2026 No. 842

INFRASTRUCTURE PLANNING

**The M25 Junction 10/A3 Wisley Interchange Development
Consent (Amendment) Order 2026**

Drawing Number	HE551522	Originator	BBA	Volume	LDC
Project	WHL_ML_M25	Role	DR - ZL	Number	020706
Location	A1	Scale	1:2500	Project Ref. No.	5195939
Original Size	A1	Sheet	6 of 9	Rev	P02

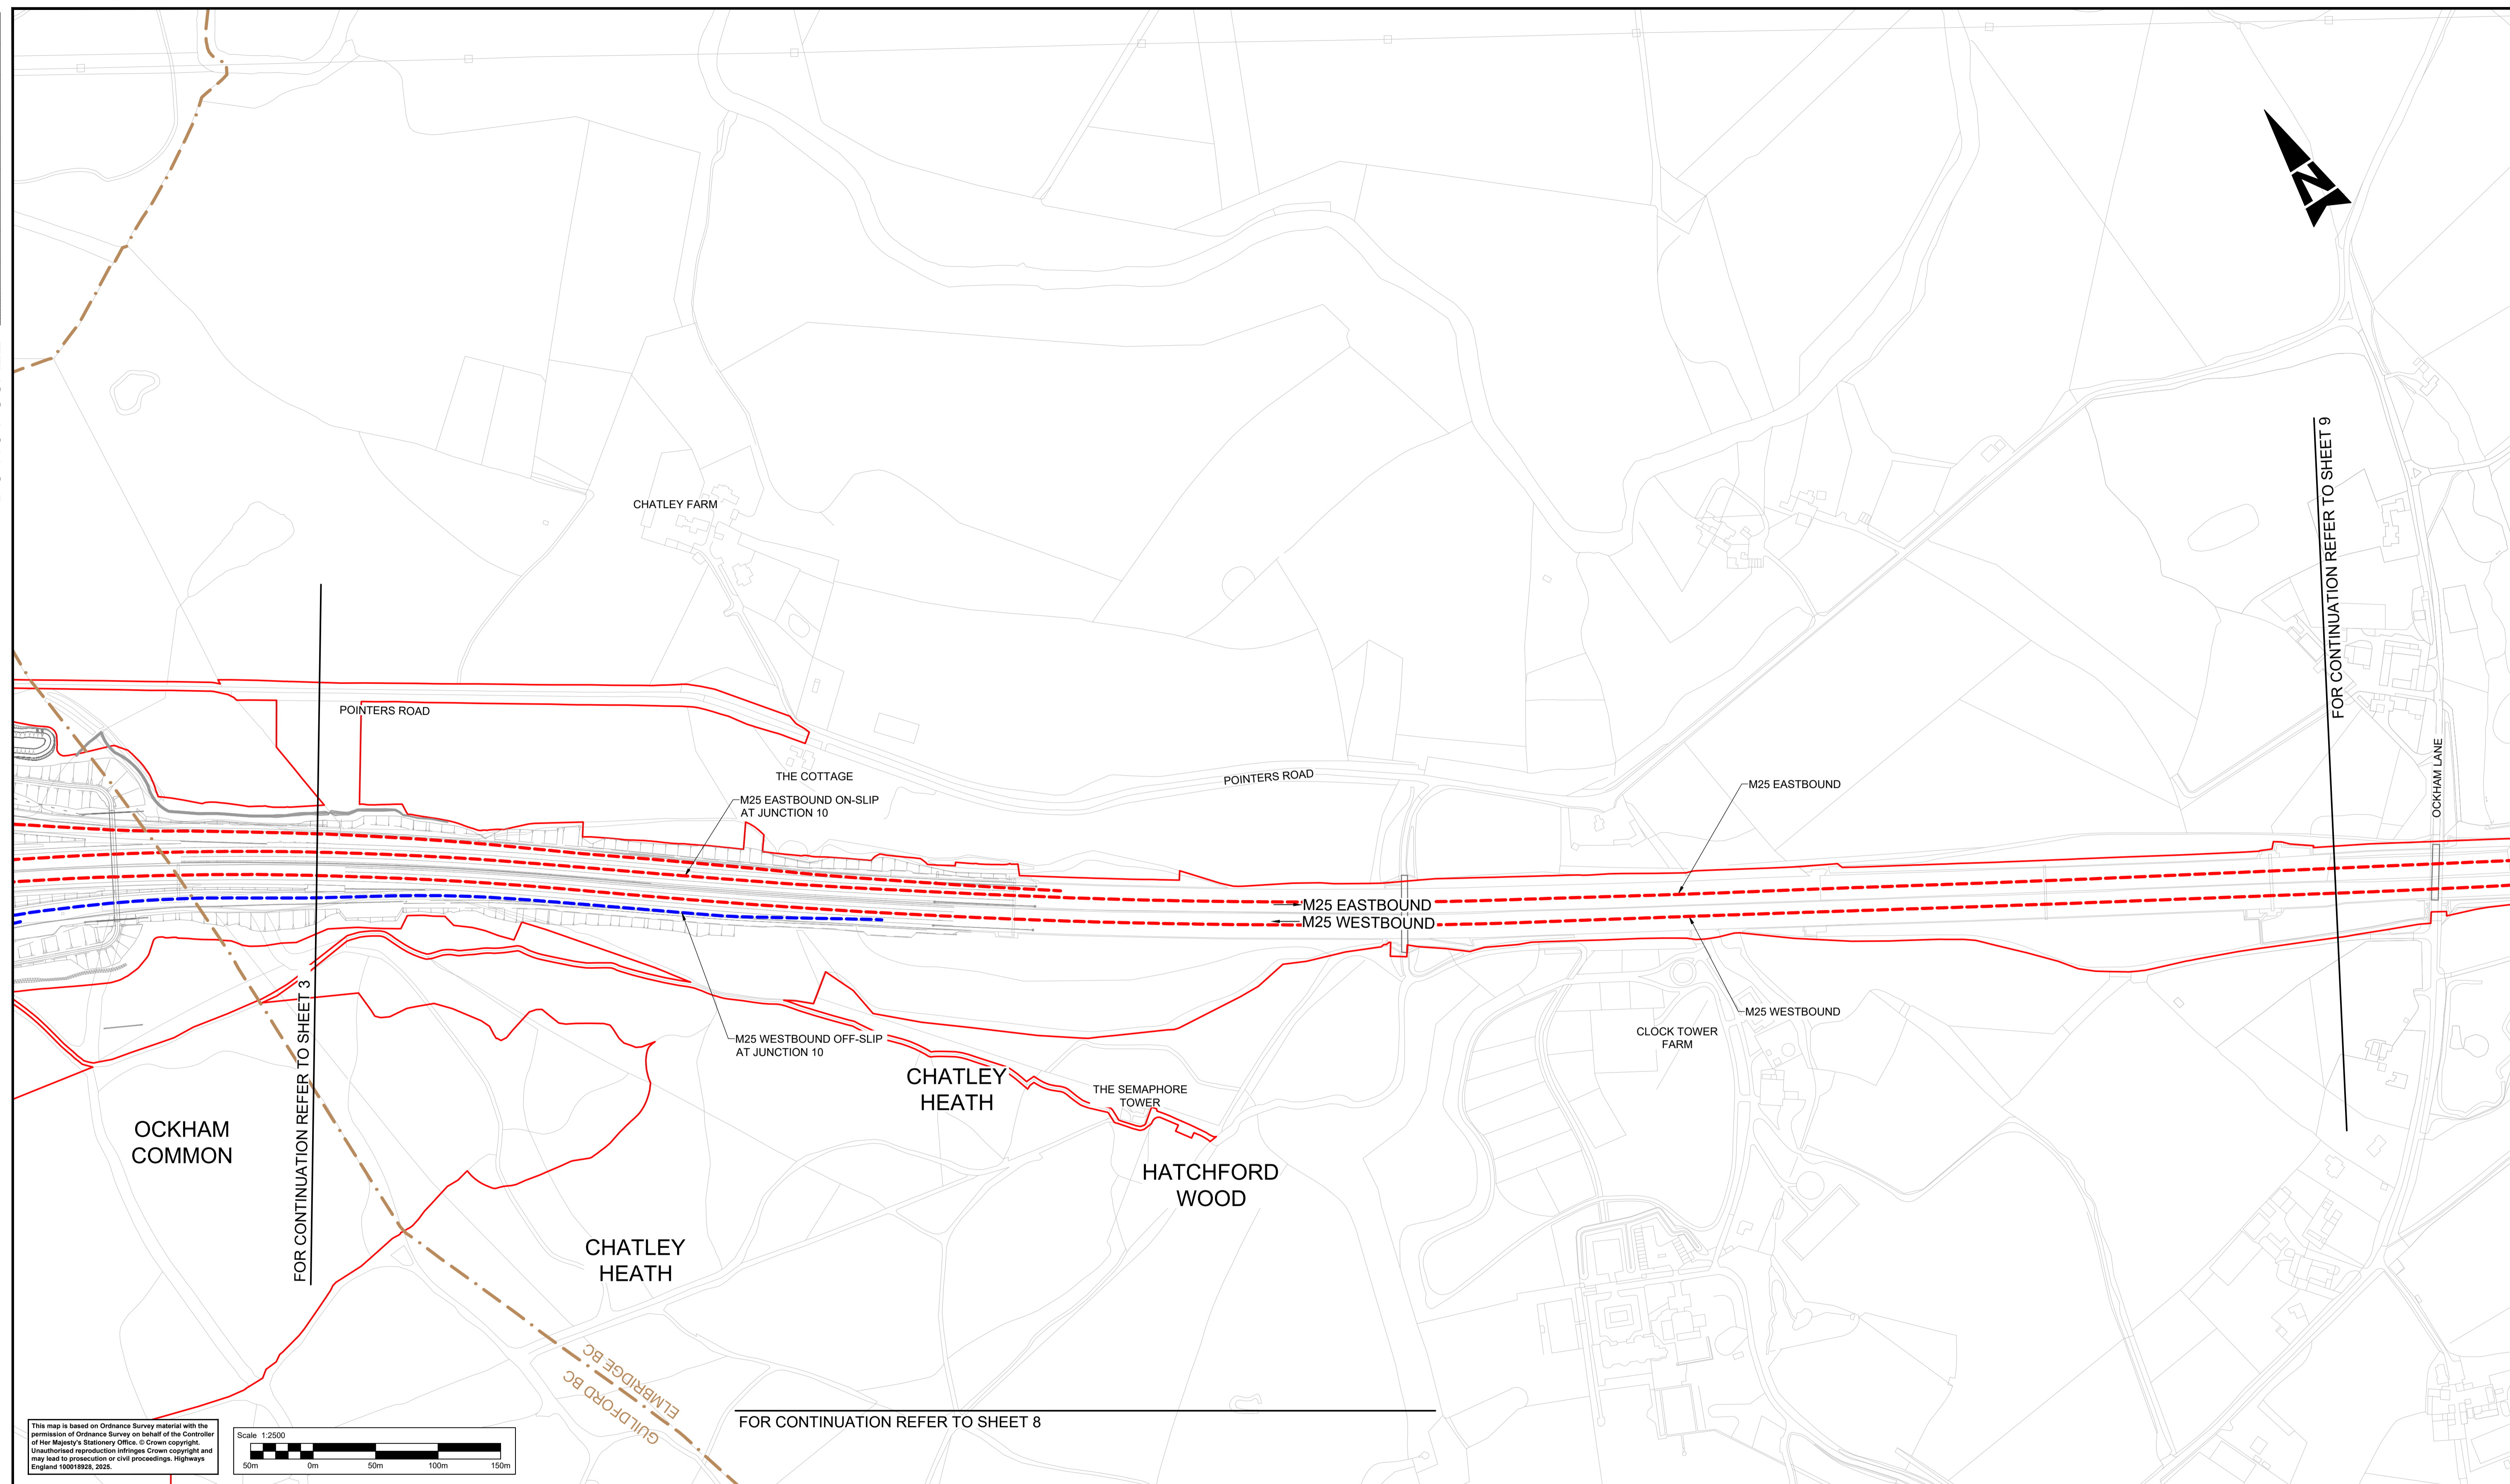
<i>(1) Road name and number</i>	<i>(2) Extent</i>	<i>(3) Speed Limit</i>
M25 eastbound	Along the length of the improved M25 eastbound carriageway, for a total distance of 5,580 metres, as shown on Sheets 3, 5, 7 and 9 of the speed limits and traffic regulations plans.	National speed limit (70 miles per hour, as existing limit)
M25 eastbound on-slip at M25 junction 10	Along the length of the altered slip road, from its diverge from the M25 junction 10 circulatory carriageway to its merge with the M25 eastbound carriageway, for a total distance of 955 metres, as shown on Sheets 3 and 7 of the speed limits and traffic regulations plans.	National speed limit (70 miles per hour, as existing limit)
M25 westbound	Along the length of the improved M25 westbound carriageway, for a total distance of 6,050 metres, as shown on Sheets 3, 5, 7 and 9 of the speed limits and traffic regulations plans.	National speed limit (70 miles per hour, as existing limit)

The table in Part 5 of Schedule 3 is amended to remove entries prescribing certain speed limits, and to remove reference to a road to which works are no longer proposed to be carried out. Speed limits for the M25 carriageway, the two free-flow slip lanes for traffic entering the M25 and the M25 on-slip roads are prescribed under the M25 Motorway (Junctions 7 to 16) (Variable Speed Limits) Regulations 2012 (S.I. 2012/2134).
